Re: Sequoia Apartments
5130 Sequoia Rd. NW
Traffic Circulation Layout
Architect's Stamp 2-25-22 (G11-D058)

Re: Traffic layout certification, 5130 Sequoia Rd NW, BP 2022-04675

No	Revision	Item	Date
SEQUOIA APARTMENTS 5130 SEQUOIA RD NW ALBUQUERQUE, NM 87120			
DRAWING TITLE			
SITE PLAN			
SEAL 	DESIGNED	PROJECT NO	
	DRAWN	SCALE	
	CHECKED	DRAWING NO	
	REVIEWED	DATE	
7/18/2024		A-100

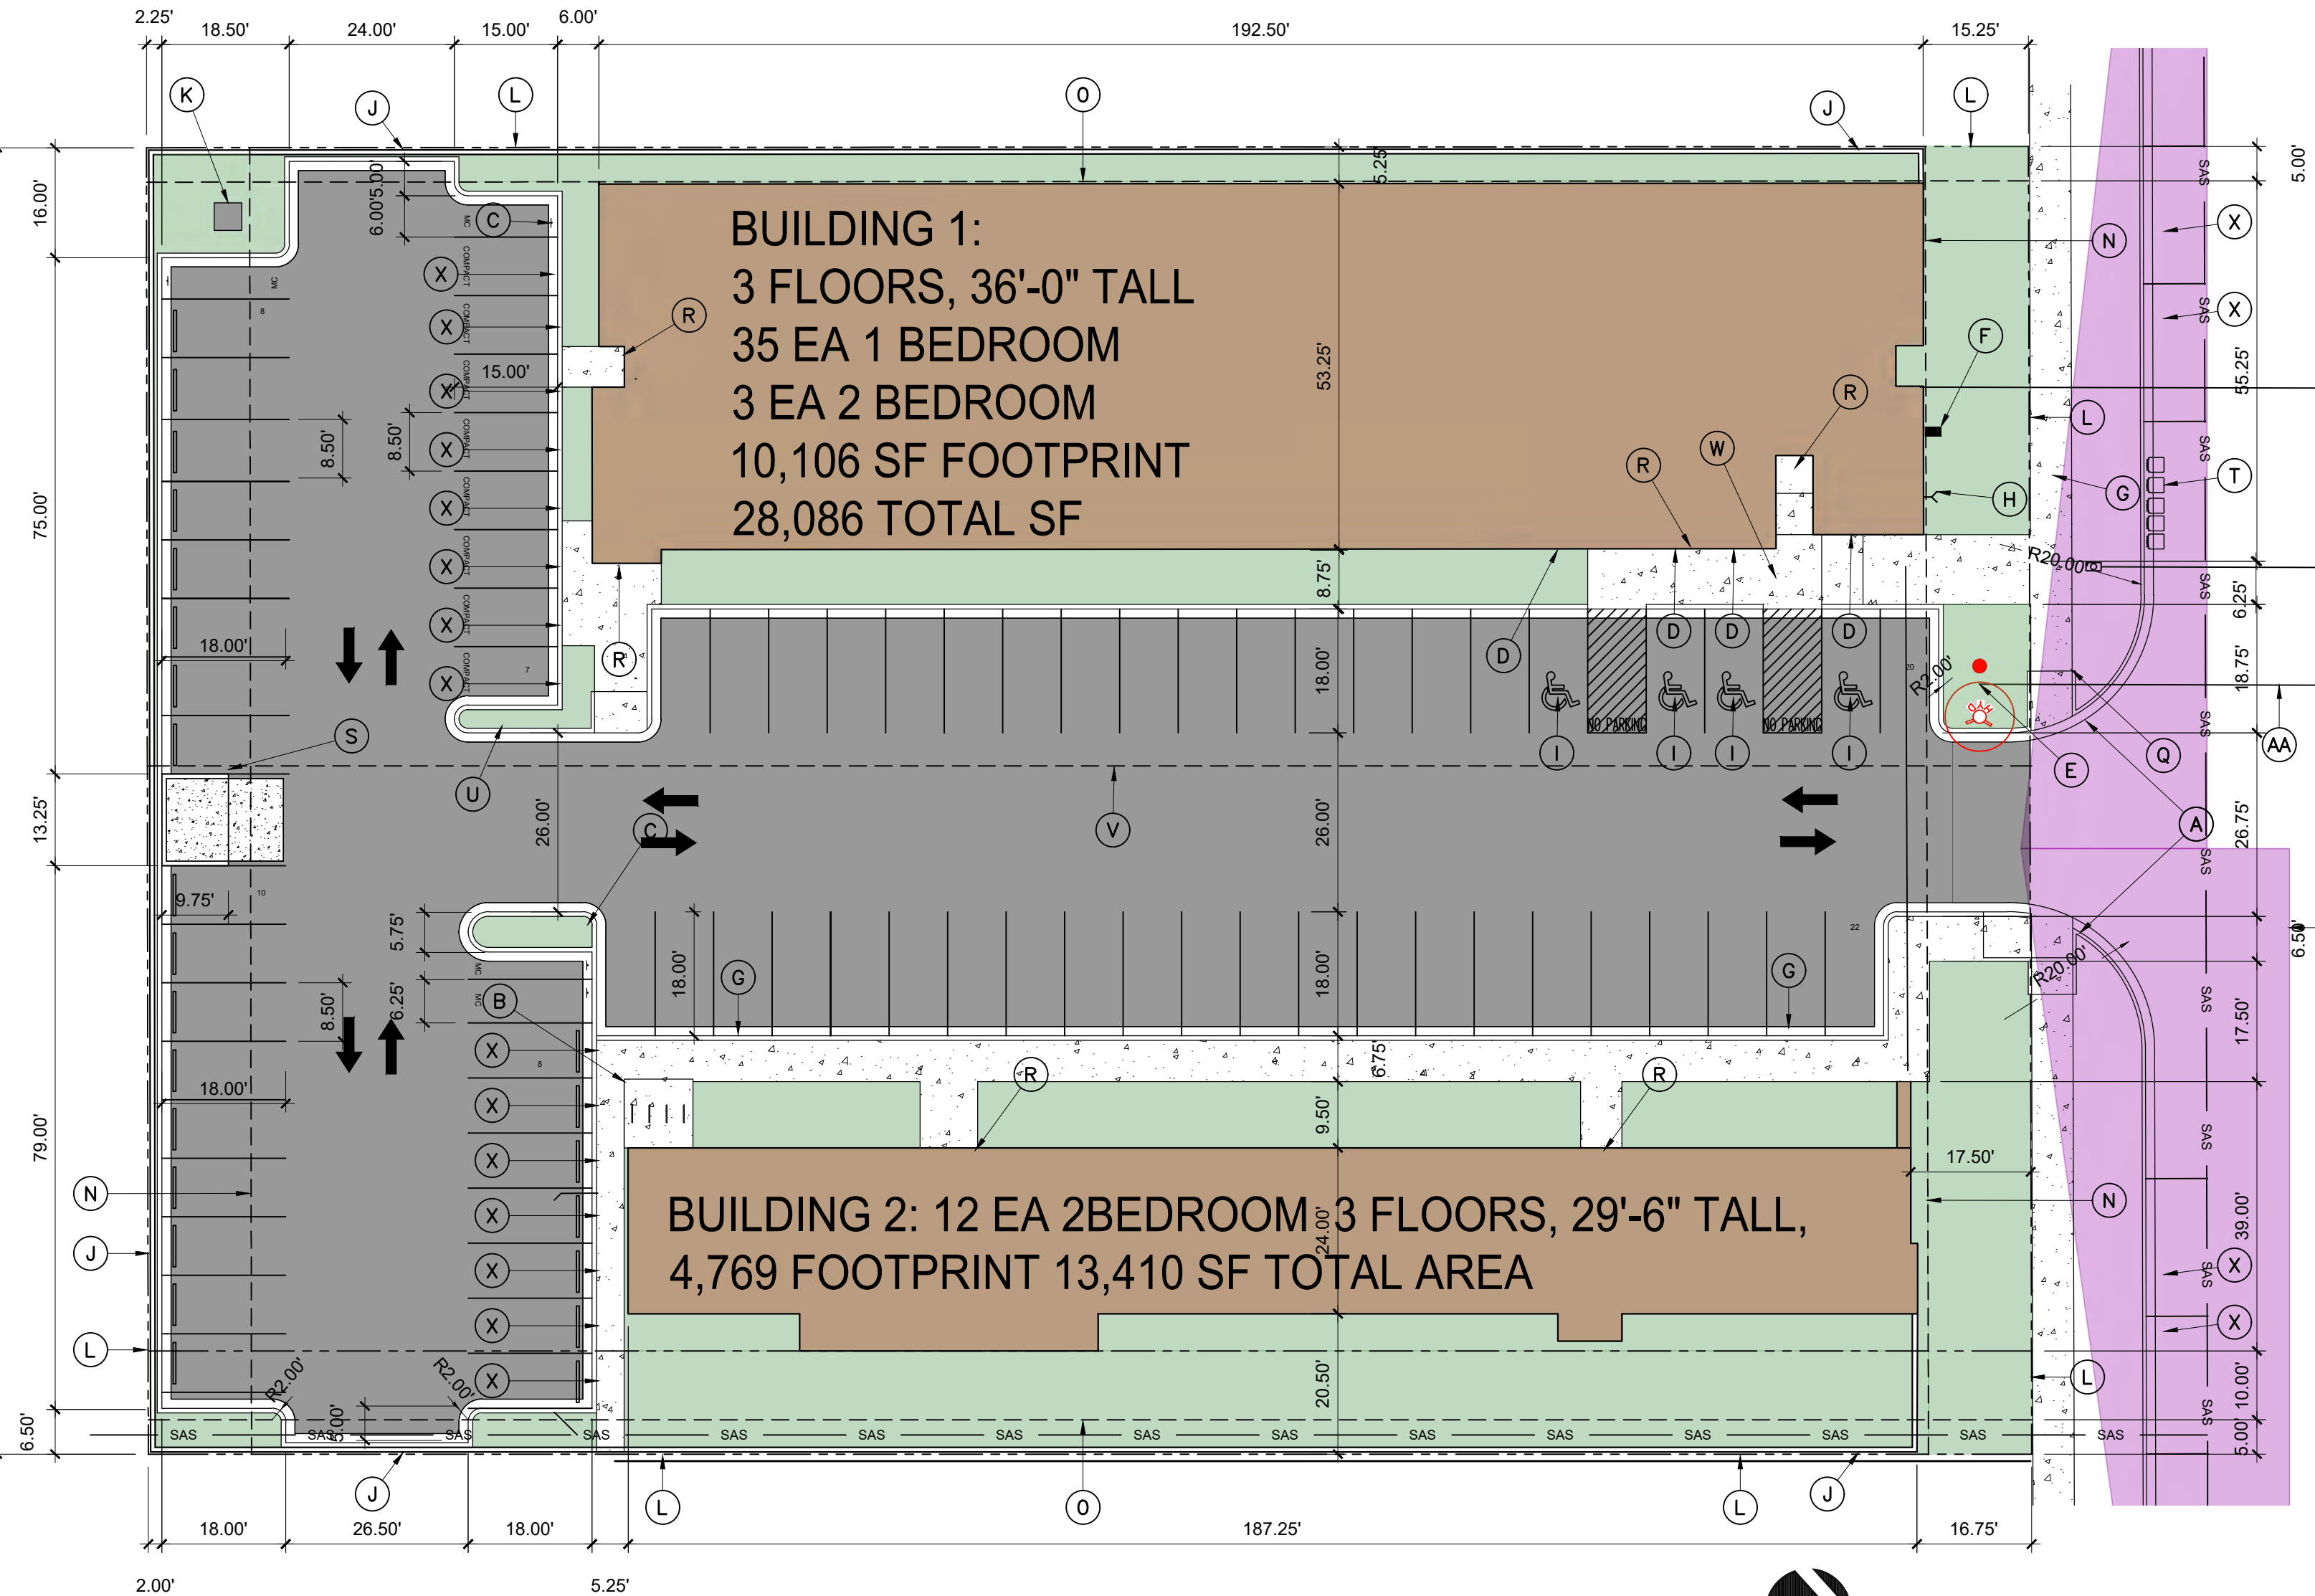
1. Keyed note "Z" changed to COA standard drawing 2444 Detail D.
2. Please reference ADA parking detail in top left corner of the sheet. On the detail a note stating " 12" HIGH LETTERING WITHIN ACCESS AISLE".
